MORGAN AND MORECAMBE OFFSHORE WIND FARMS: TRANSMISSION ASSETS

Works Plans - Onshore and Intertidal – Part 1 of 2

December 2024
Rev: F02

PINS Reference: EN020028
APFP Regulations: 5(2)(j)
Document reference: B8/F02

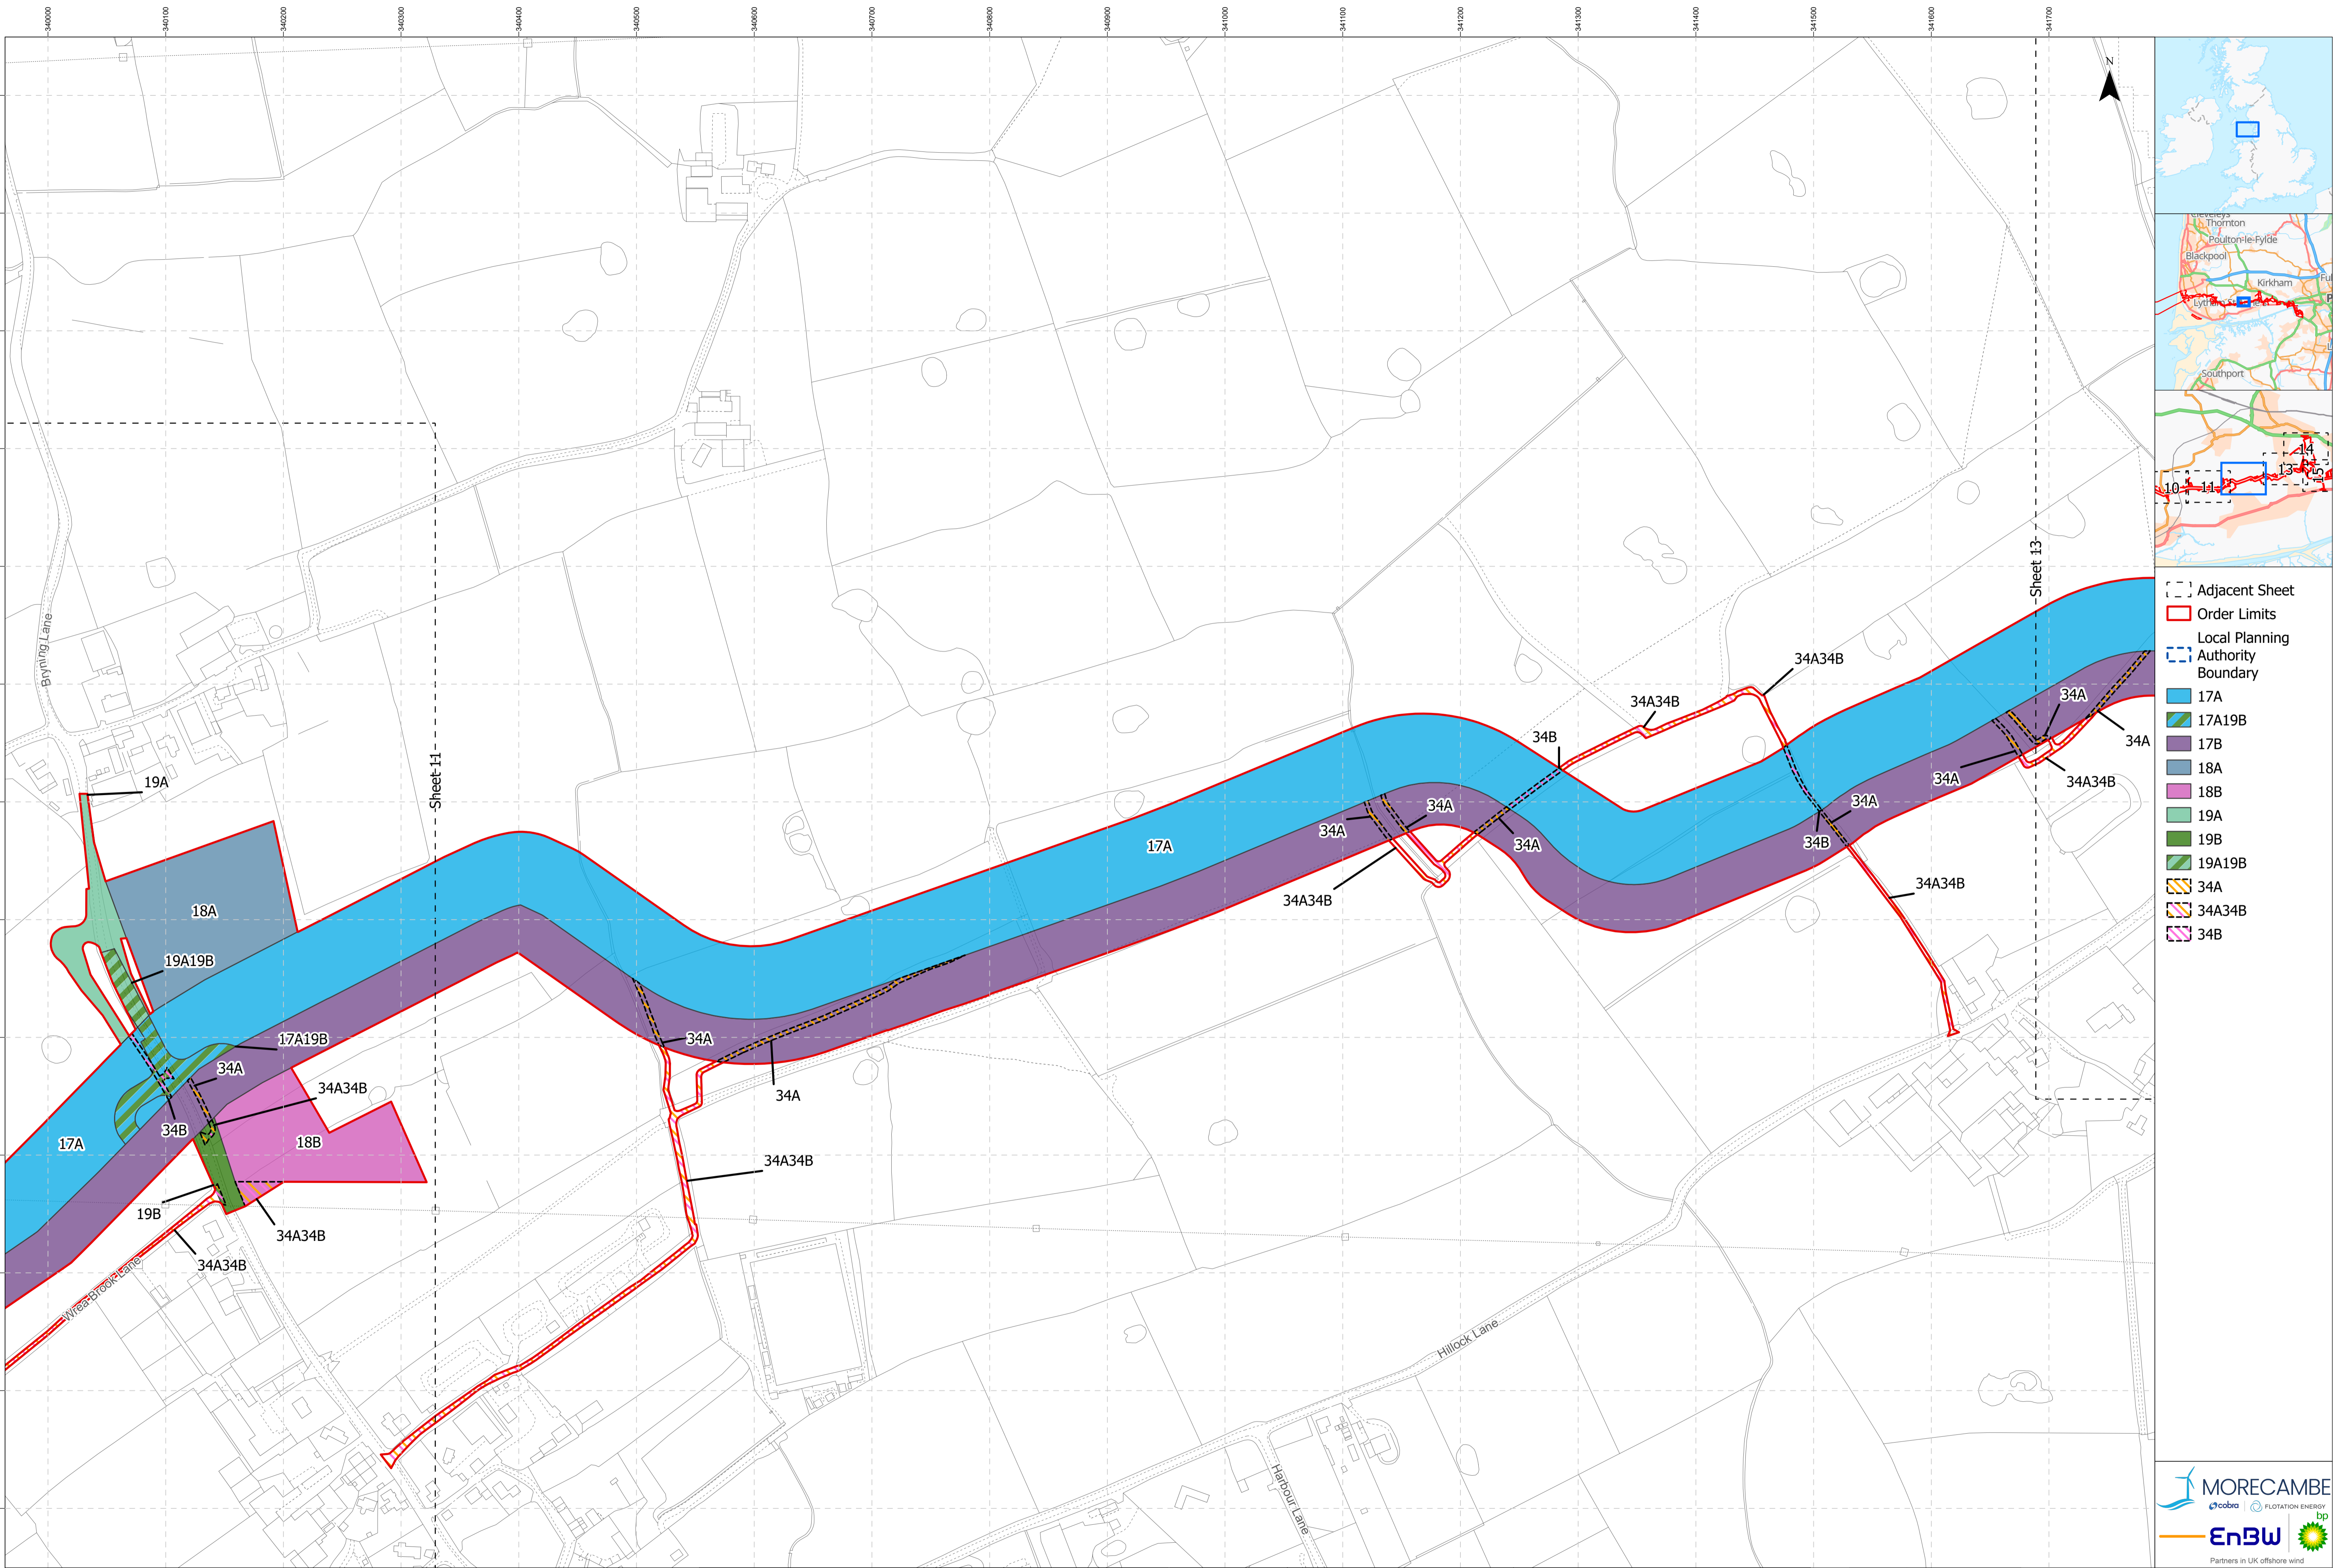
Sheet Number	Change requested by	Change Made	Reason for Change	Revision	Submission deadline
9	The Applicants	Permanent access (Work No. 34A34B) off Wrea Brook Lane has been removed.	A review of the works plans identified that permanent access (Work No. 34A34B) was not required at this location.	F02	S51 advice update
13	The Applicants	The permanent access to Morecambe onshore substation (Work No. 23B) east of Lower Lane has been updated to the Morecambe onshore substation construction access (Work No. 24B).	A review of the works plans identified that the permanent access (Work No. 23B) should be changed to construction access (Work No. 24B) as it is only required to connect the two temporary construction compounds.	F02	S51 advice update
14	The Applicants	Construction and permanent access to environmental mitigation works (Work No. 40B41B) has been removed, off the A583.	A review of the works plans identified that construction and permanent access to environmental mitigation works (Work No. 40B41B) was not required at this location.	F02	S51 advice update
